Application by Beacon Fen Energy Park Ltd for an order granted development consent for the Beacon Fen Energy Park

Written Representation

**A report prepared by North Kesteven District Council
(ID F8D379496)**

Planning Inspectorate reference: EN010151

DO NOT SCALE FROM THIS DRAWING

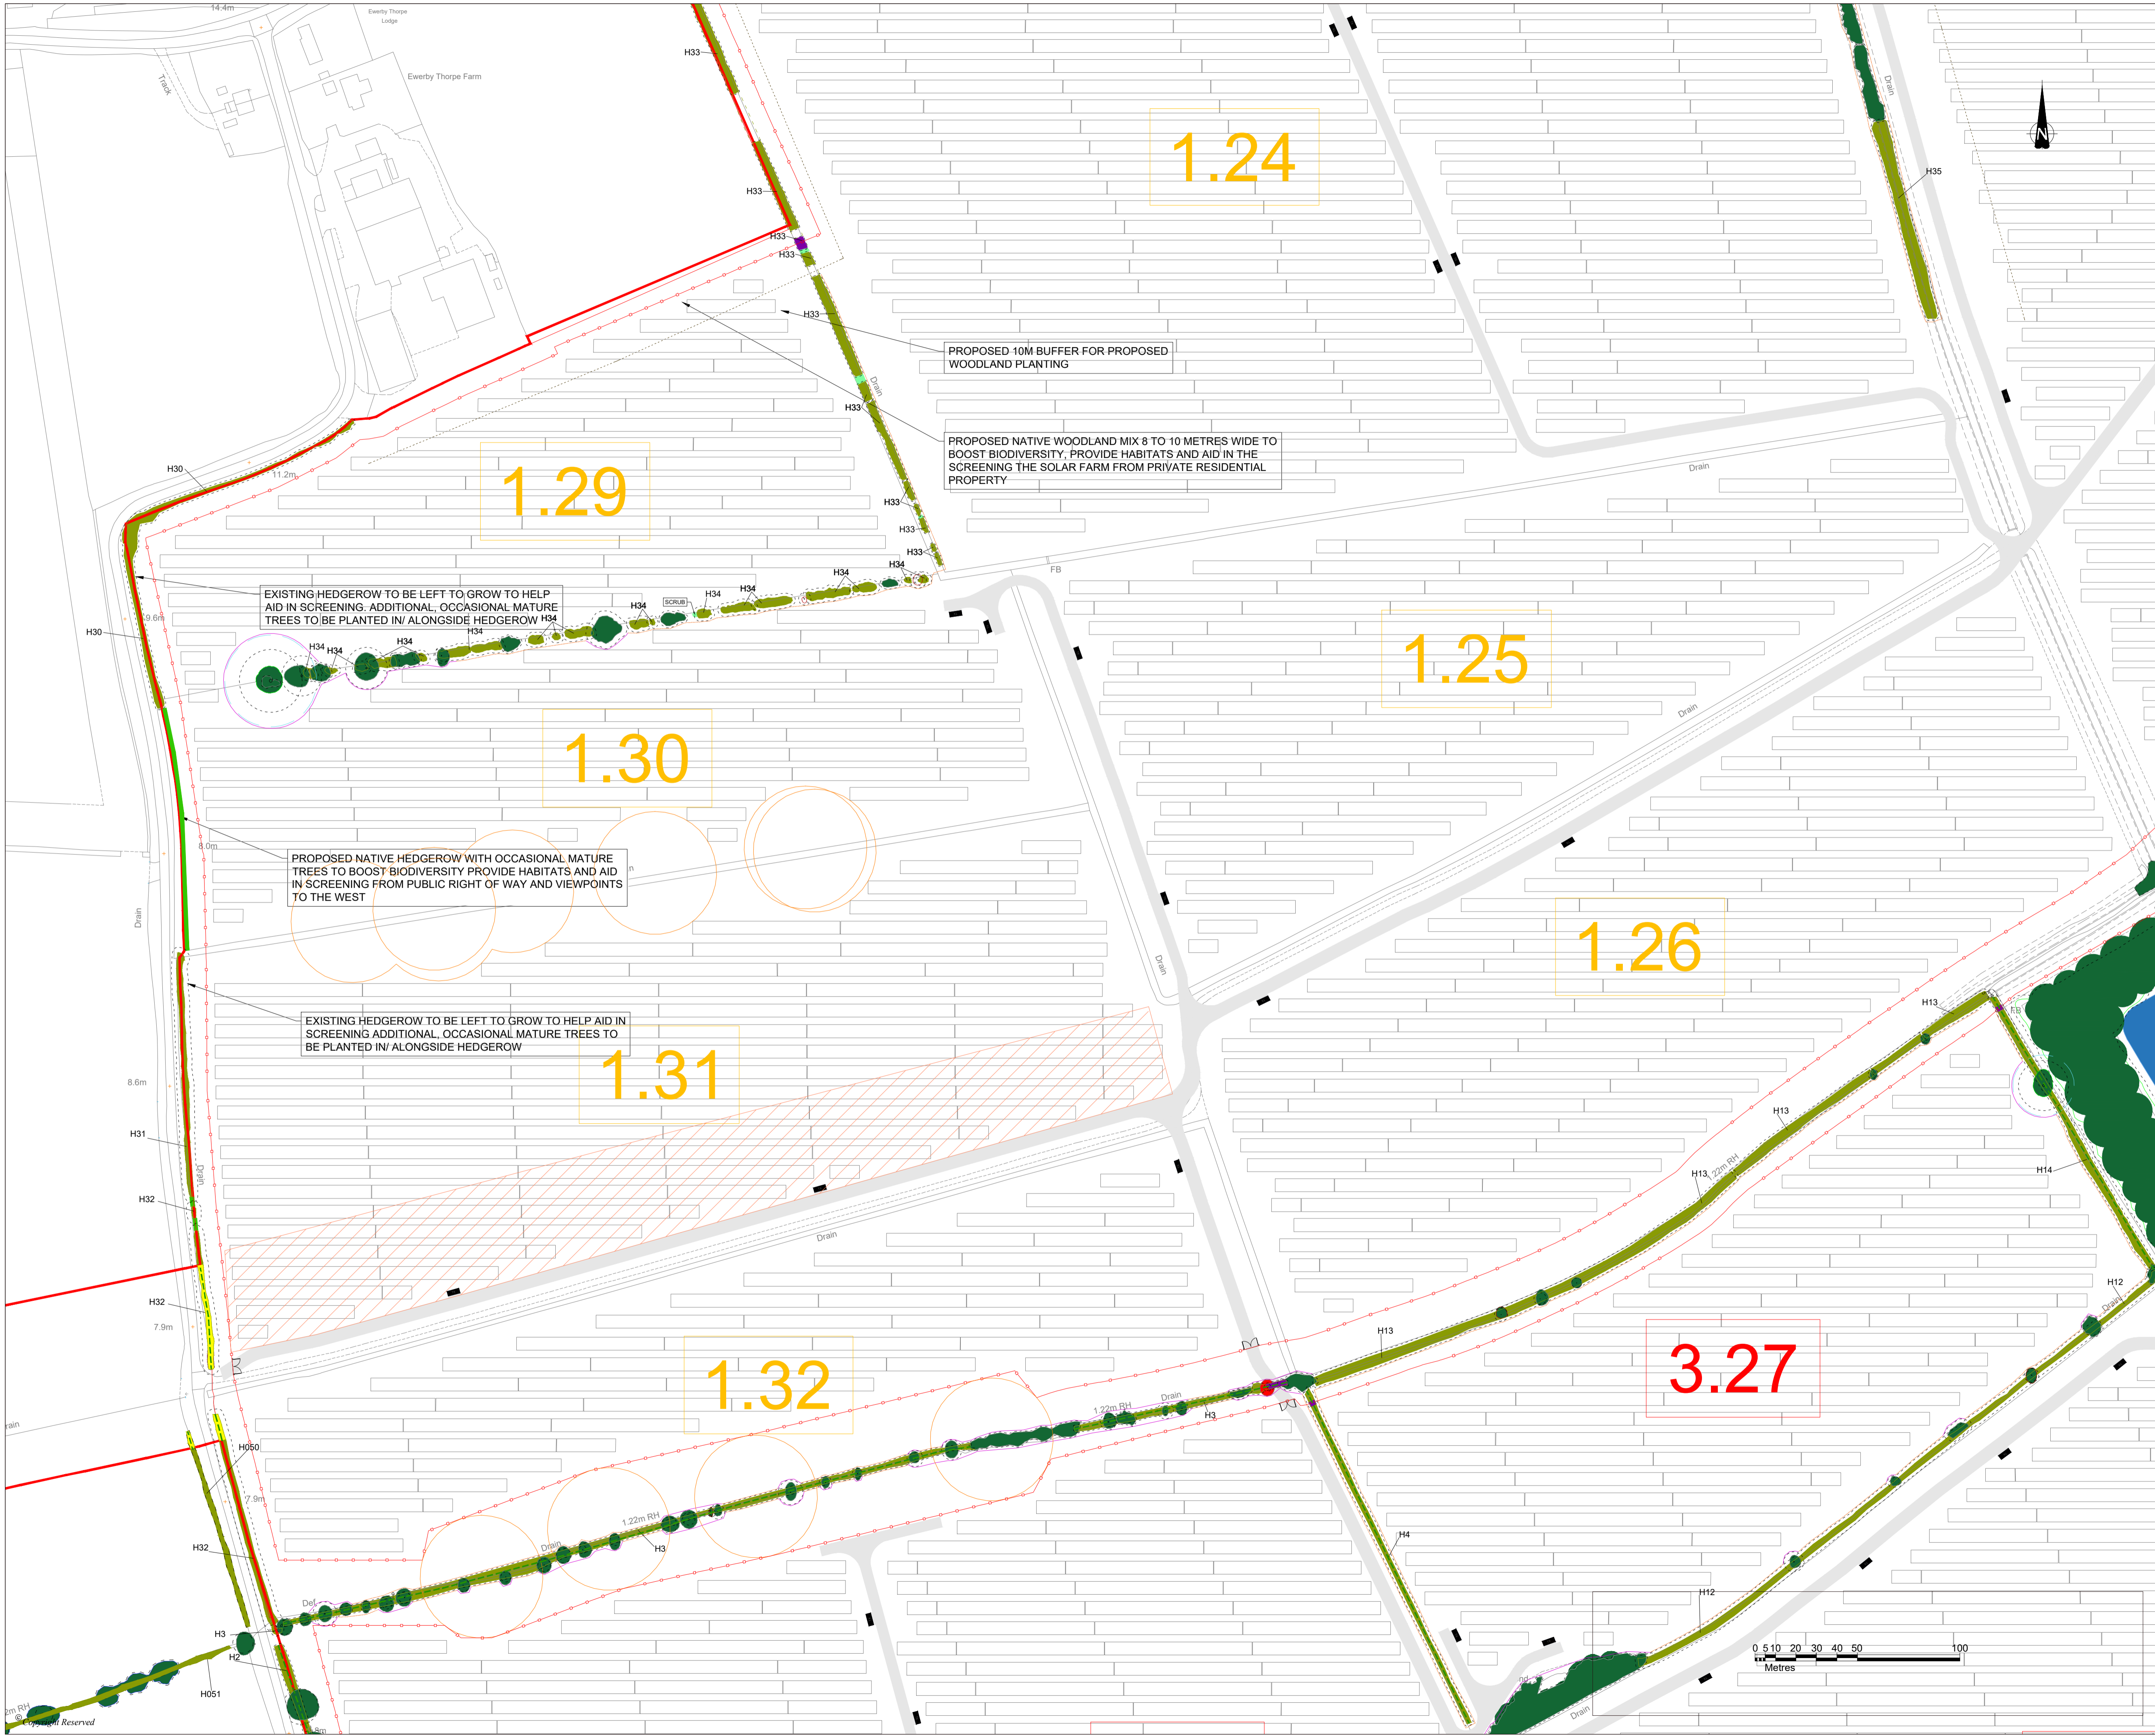
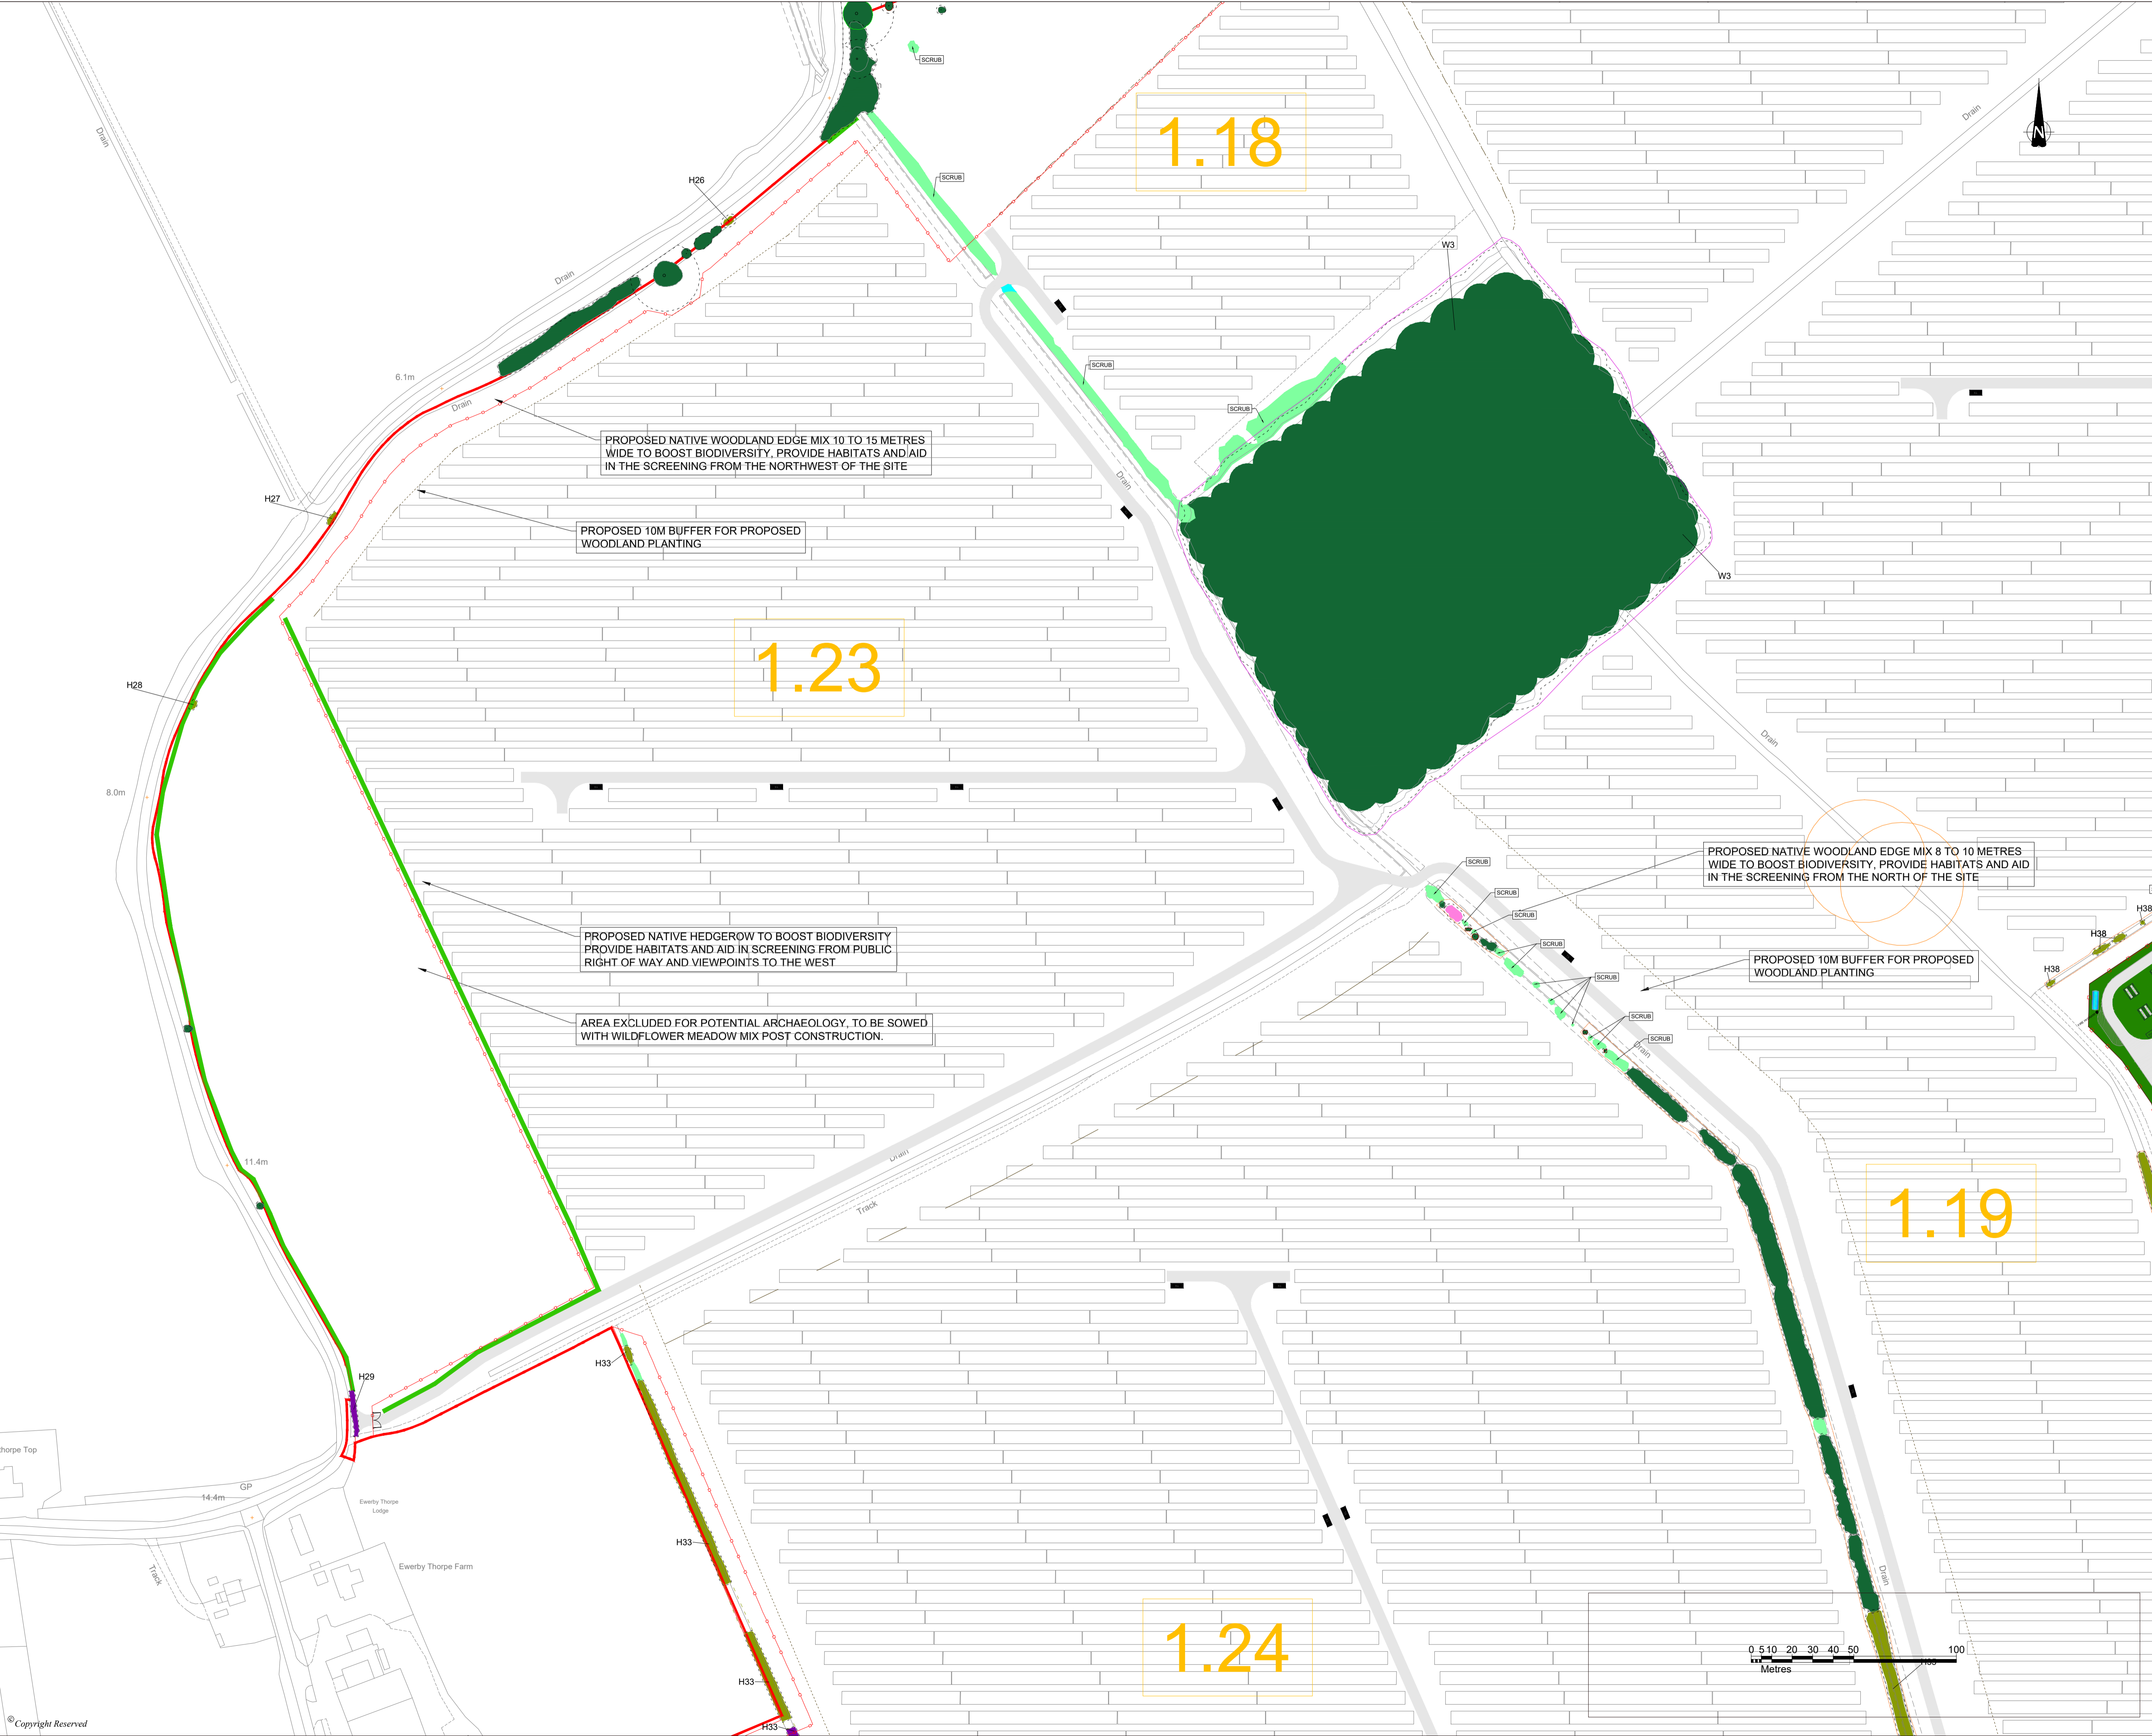
- 4.16 The proposed localised removal of vegetation is identified in the assessment of landscape effects; however, it is unclear whether this includes vegetation works on the wider highways network, and what this would entail. AAH strongly recommend limiting vegetation loss along the site boundaries for access or sight lines, or along construction access routes, because this has the potential to change the character of the local landscape beyond the limits of the development.
